**RE: The Park Danforth
777 Stevens Avenue
Amended Site Plan and Subdivision Review**

On behalf of "The Park Danforth", we are pleased to submit the following Amended Site Plan and Subdivision Application for the proposed expansion of "The Park Danforth" located at 777 Stevens Avenue in Portland. The Park Danforth is requesting to construct three (3) additional one bedroom dwelling units on the fifth floor along the Arbor Street frontage. Since the planning board approval on February 10, 2015, detailed architectural plans have been developed and construction cost of the new addition and site improvements have been refined. It has been determined that providing the three (3) additional units significantly improves the financial success of the project. That being said, there have also been some value engineered building elements that have been identified as future construction. The modifications are further defined below.

**10 L&G** REINFORCED CONCRETE DRIVEWAY APRON  
 EMERGENCY ACCESS ONLY ENTRANCE- STEVENS AVENUE  
 NOT TO SCALE

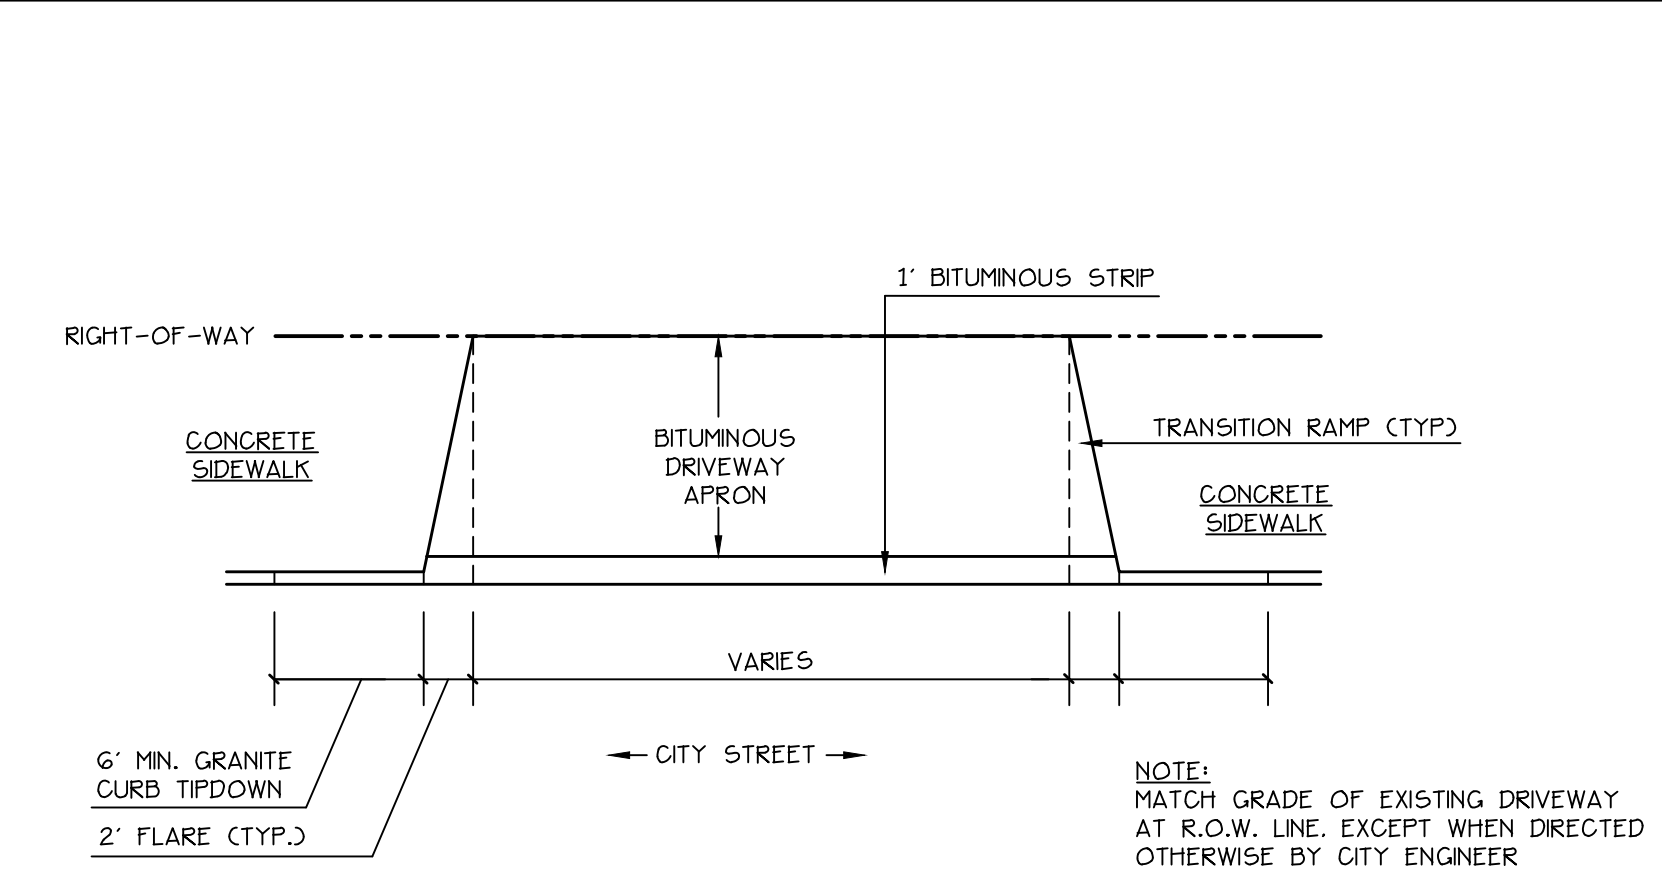
1. Site Plan has been revised to address fire department request to change interior curb radius to allow easier emergency vehicle access. In addition, a raised mountable concrete island has been added to the Stevens Avenue right turn in curb cut to allow emergency vehicles to enter or exit to the site.
